Preliminary and Final DRAINAGE PLAN AND REPORT ROCKY TOP MOTEL AND CAMPGROUND

10090 W Highway 24
A portion of the NW ¼, Section 9, Township 13 South, Range 68 West
EL PASO COUNTY

Revises
December 19, 2022

EPC STORMWATER REVIEW COMMENTS
IN ORANGE BOXES WITH BLACK TEXT

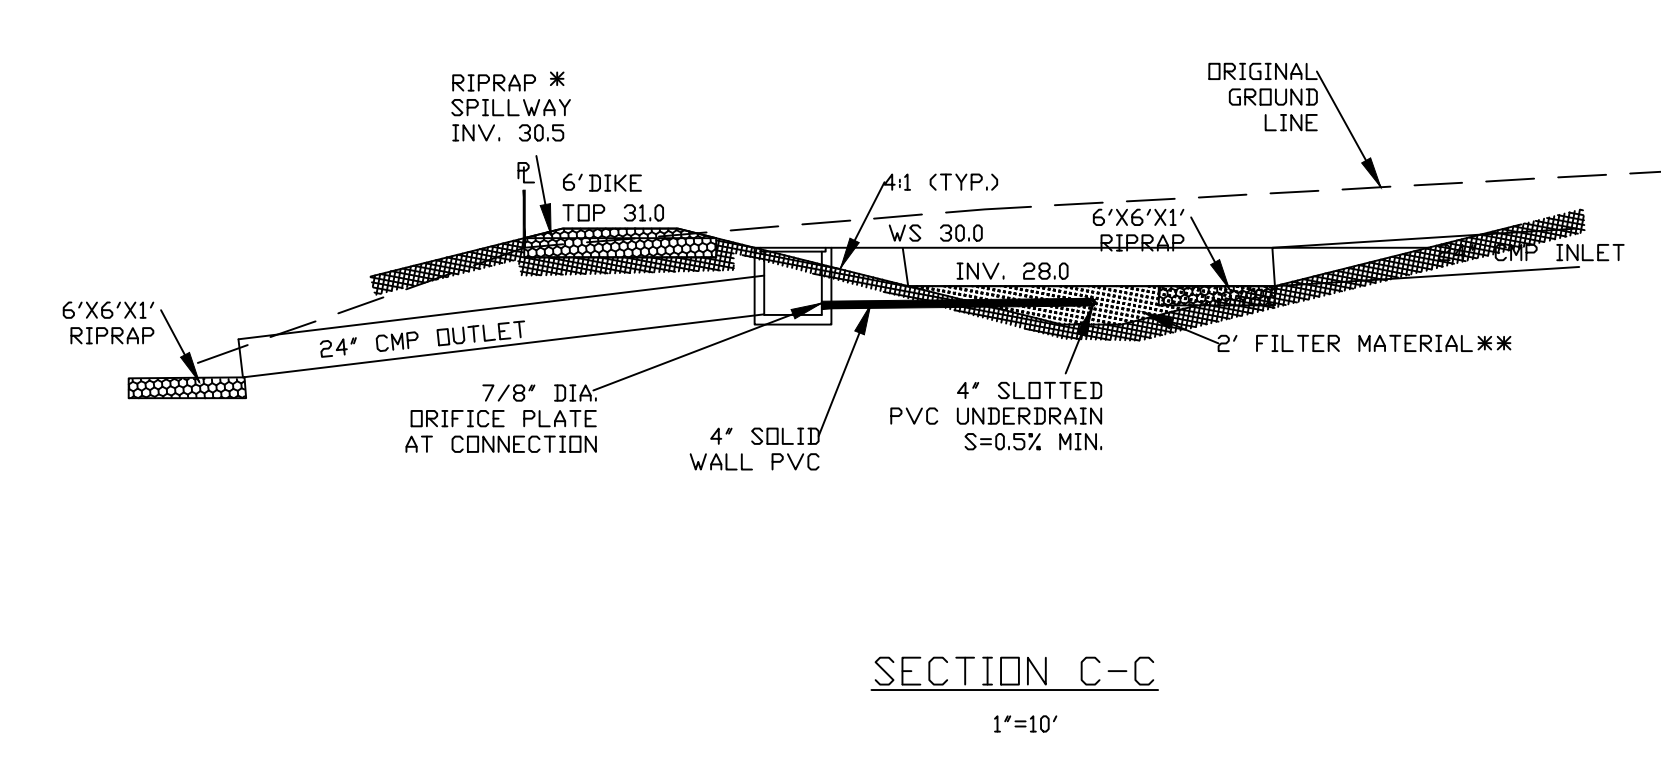
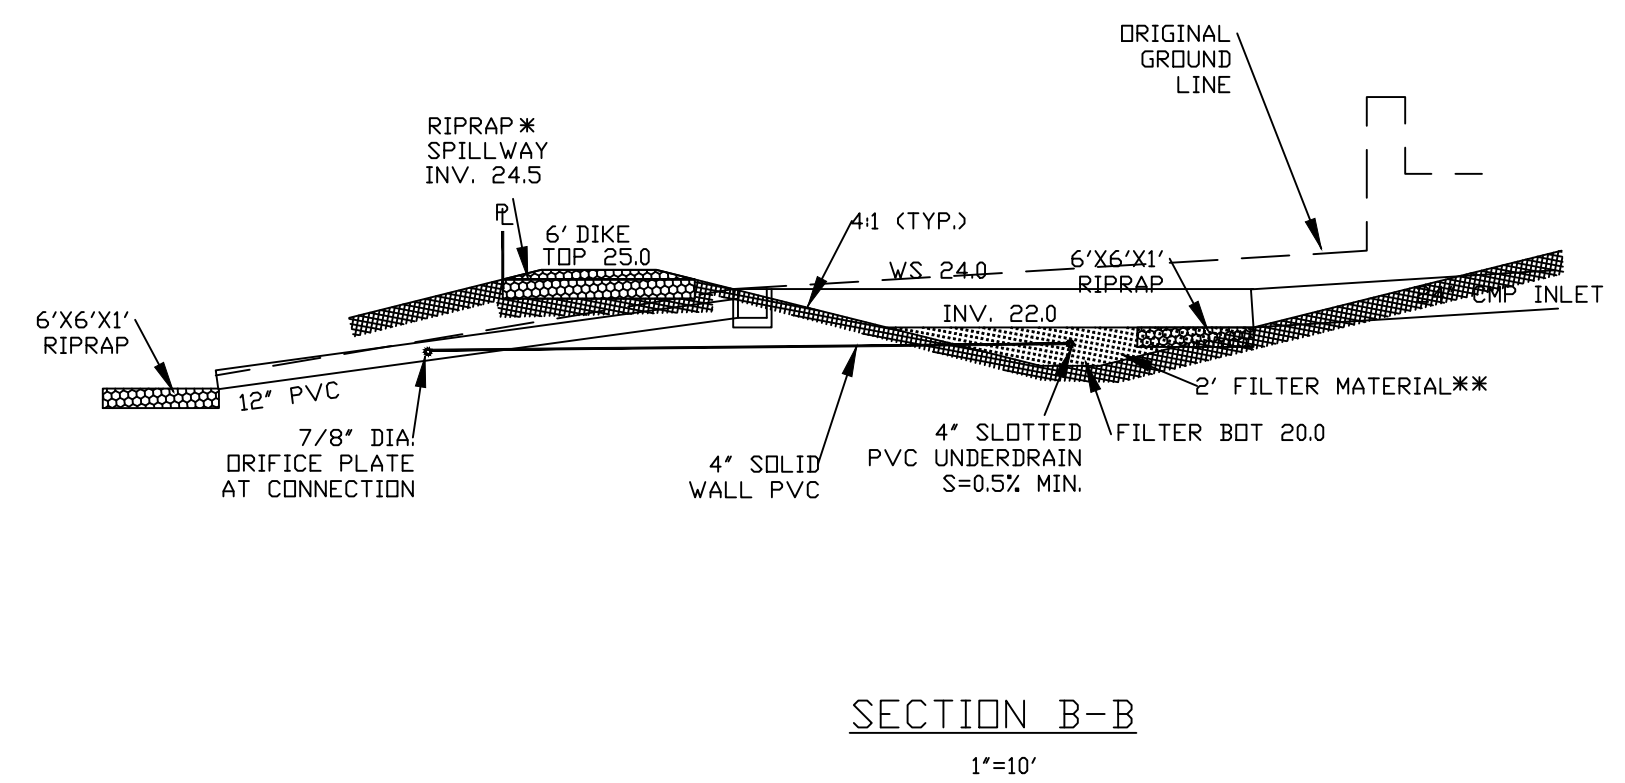
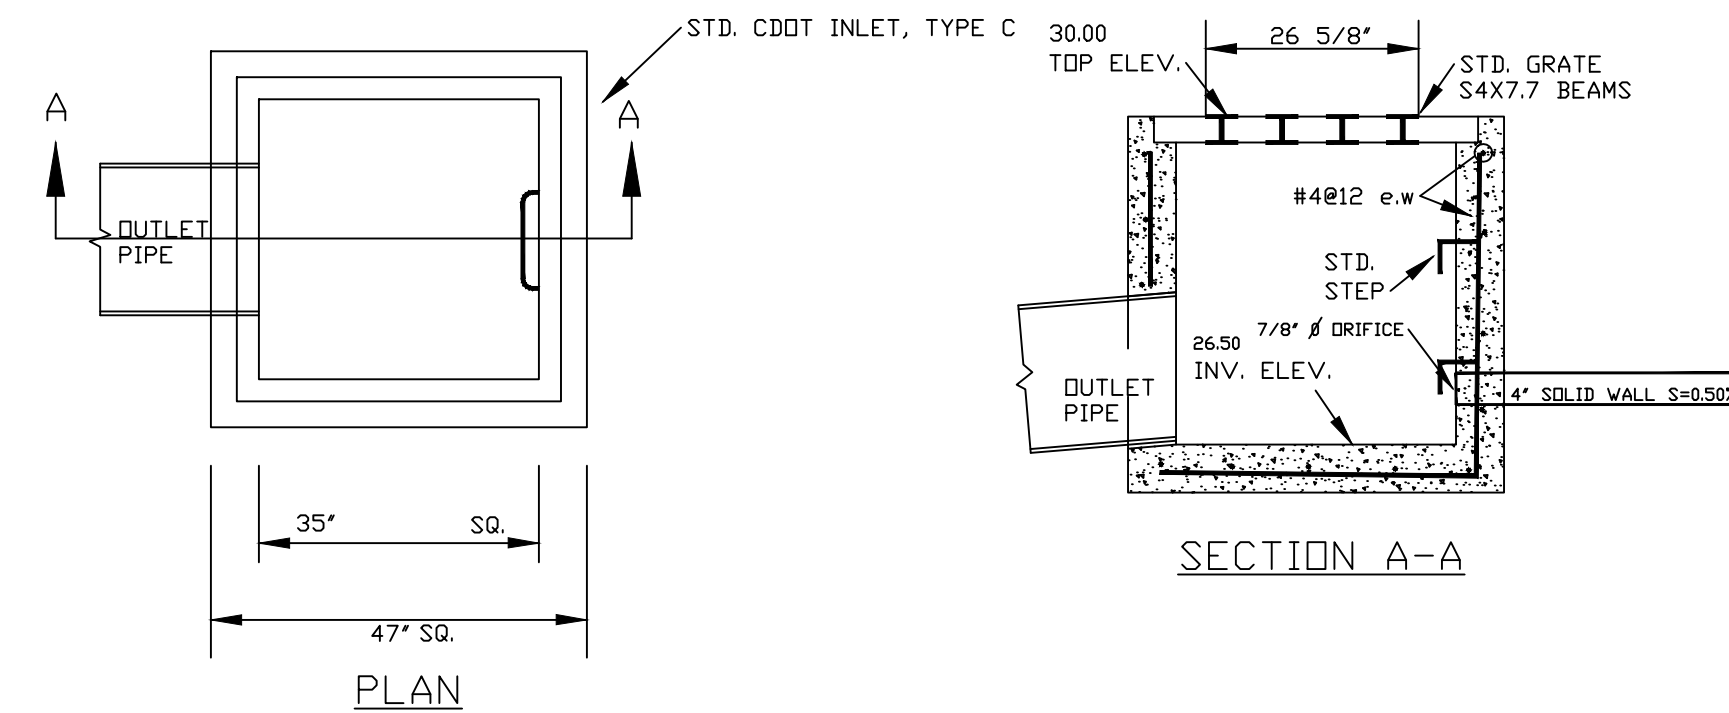
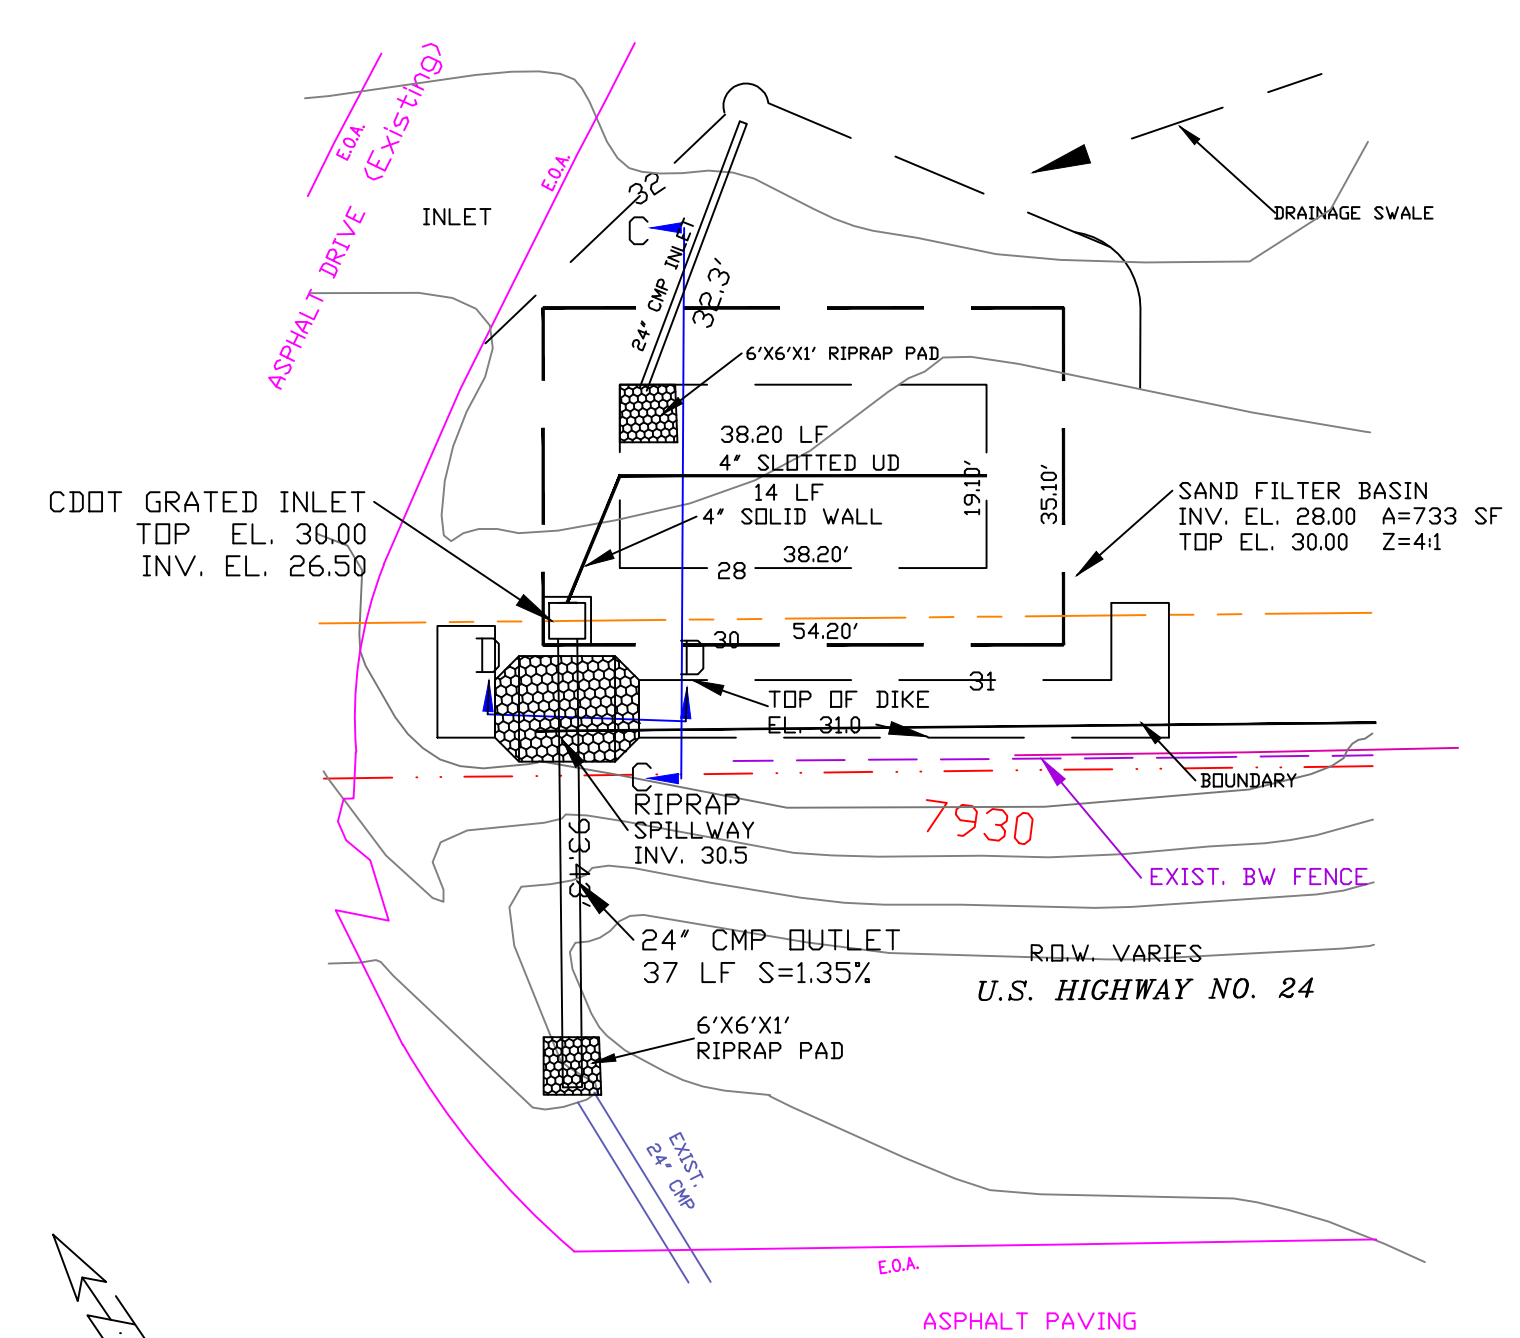
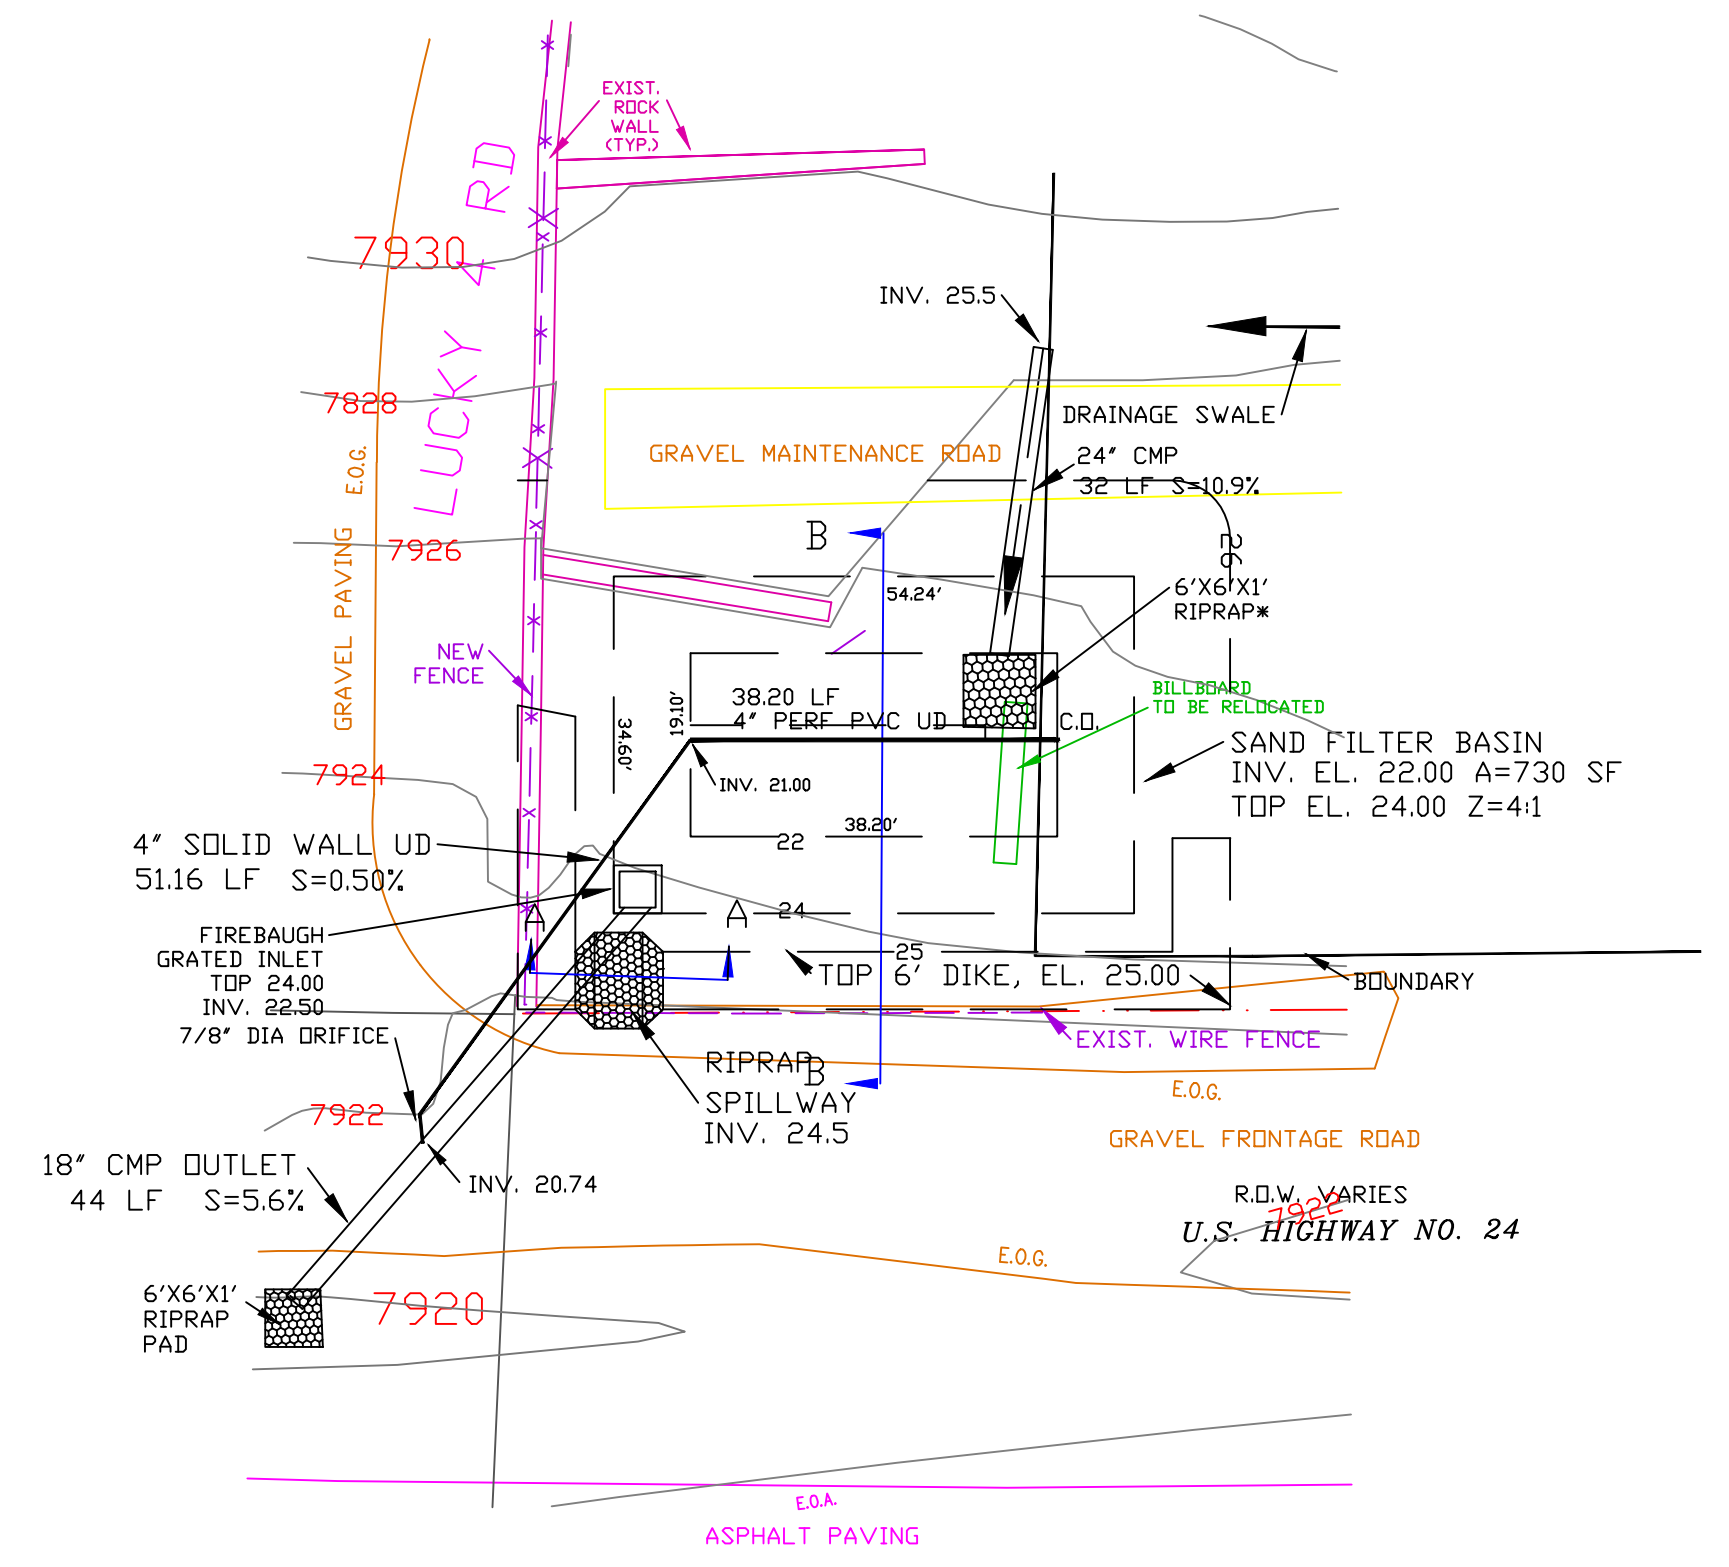
1.5ft here does not match what is shown on the plans. The plans show the bottom of the pond at 22ft elevation and inv of 4" pipe at connection to 18" pipe at 20.74ft. So something isn't right. Revise calcs and/or plans as needed to remove this discrepancy.

Cannot confirm whether or now 1.5ft here does matches what is shown on the plans. The plans show the bottom of the pond at 28ft elevation and inv of 4" pipe at connection to inlet box is unknown (not shown in plans). Revise calcs and/or plans as needed to clarify and to reflect this 1.5ft distance.
